Suffolk County Council (20050784)

Answers to Examining Authority's Third Written Questions (ExQ3)

North Falls (EN010119)

15 July 2025

1 New visualisation (VP9) from Barn Lane - Grange Road

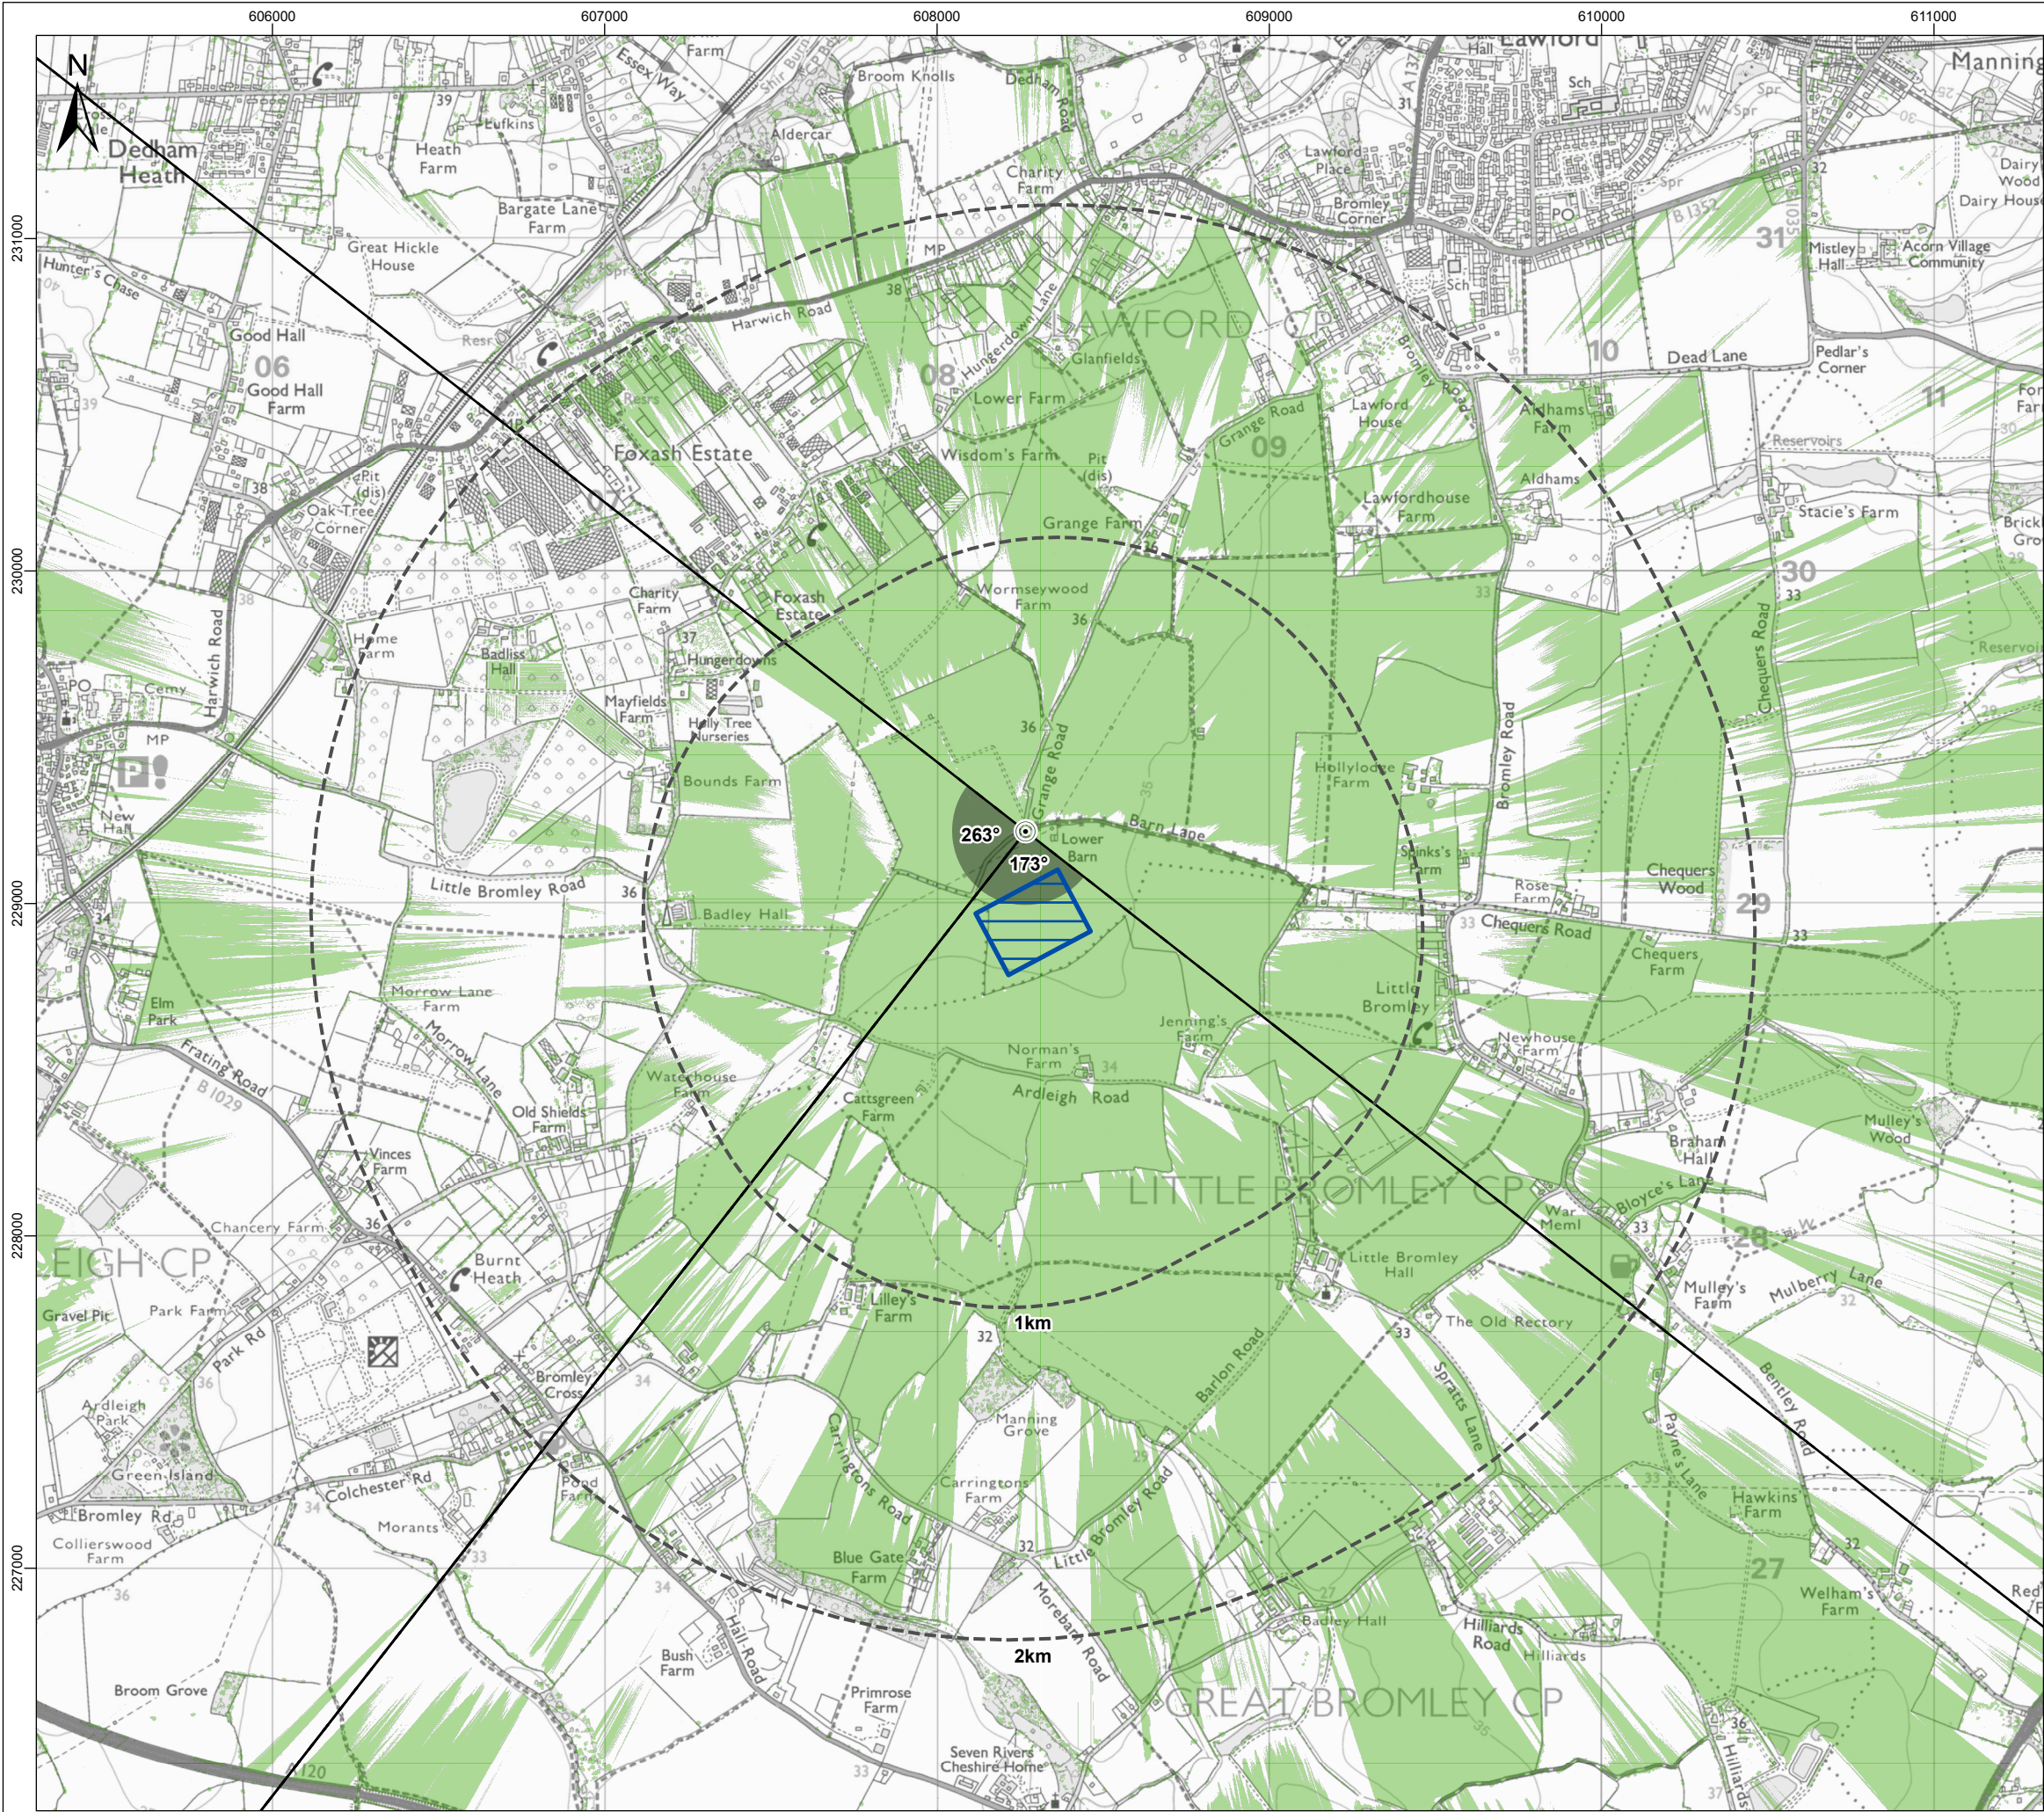
Q14.0.15	Applicant, ECC/ other IPs	<p>New visualisation (VP9) from Barn Lane - Grange Road</p> <p>In response to ExQ2 14.04, the Applicant stated that it would be providing an additional photomontage visualisation from Grange Road, to be submitted at</p>	<p>SCC welcomes the additional viewpoint, as it presents what might be visible, albeit from a greater distance, from the Dedham Vale National Landscape. SCC has previously requested an additional viewpoint, but this has so far not been produced.</p> <p>Without prejudice to the narrative which may be provided by the Applicant at Deadline 7, the photomontages demonstrate the level of adverse</p>

ExQ3	Question to:	Question:	SCC Answer:
		<p>Deadline 6. The selected viewpoint is immediately north of the proposed onshore substation works area. The ExA notes [REP6-065] and [REP6-066] provide new visualisations for new Viewpoint VP9.</p> <p>This appears to currently be absent of corresponding narrative, such as that which accompanies VPs 1 to VP8 within Chapter 30 of the ES (see Tables 30.21 to 30.28).</p> <p>i) In the interest of consistency and completeness, please can the Applicant provide an update to VP9, or signpost to where this information is contained by Deadline 7.</p> <p>IPs are invited to comment on VP9 photomontages at this stage, and following Deadline 7, to comment further on the accompanying narrative.</p>	<p>landscape and visual effects, which SCC considers could be significant. This is on account of the substantial change to the view caused by the proposed substation. The viewpoint is quite close to the site, but demonstrates what might be visible from the Dedham Vale, albeit at a greater distance and with potential filters/screens.</p> <p>SCC is concerned with regards to the assumed height and density that can be achieved by the proposed mitigative planting by year 15 (growth rates).</p> <p>Referring to the Landscape Mitigation Plan, Figure 30.1.6, in ES Chapter 30 – Figures (Part 1 of 6) [APP-083], SCC would expect the proposed native trees south of the junction of Grange Road and the bridleway and north of the existing overhead powerline to provide filtered views, rather than a solid screen, towards the new woodland planting around the substation in the middle ground, and elements of the substation visible beyond.</p> <p>In technical terms, a slight overlap across the images for the two parts of the viewpoint would have been helpful.</p> <p>Given the time of year during which the viewpoint was produced, it is accepted that only summer views could be made available.</p> <p>However, the year one planting does not appear to be included in the photomontages. While the planting would have been small, and mainly consisted of tree and shrub shelters, it would have aided the understanding of where mitigation planting would be implemented in relation to the substation and the viewpoint, as well as of the progression to the images for year 15.</p>
